Final Report - Corrections Required **Application No. LUPL-25-0008**

Report Date: 07/14/2025

City of Colorado Springs Project: ZONE-25-0021 - BLR Village C - MX-M Rezone

LUPL-25-0008 - BLR Village C - Land Use Plan

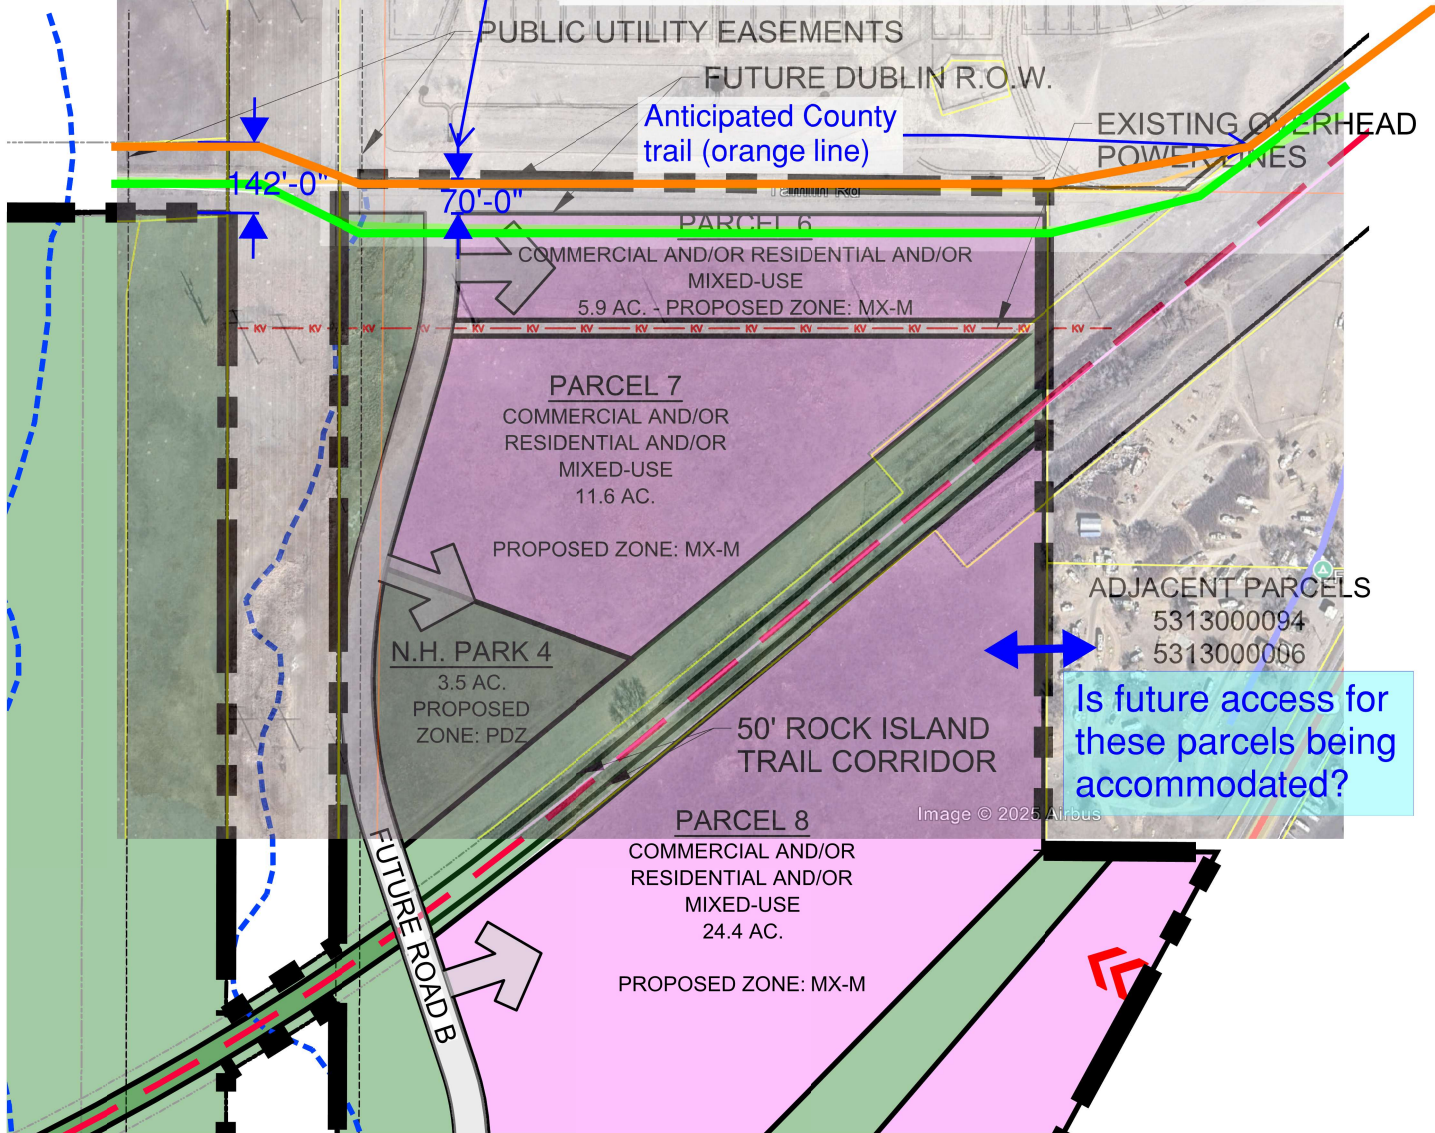
1. Note: Coordination is needed between the developer, the City and EPC (DPW and Parks) regarding the Dublin Blvd./Falcon Highway alignment. See attached sketch/redlines.
2. Is future access (secondary) for the Falcon Meadow Campground parcels being accommodated? (Reference US HWY 24 Access Control Plan)
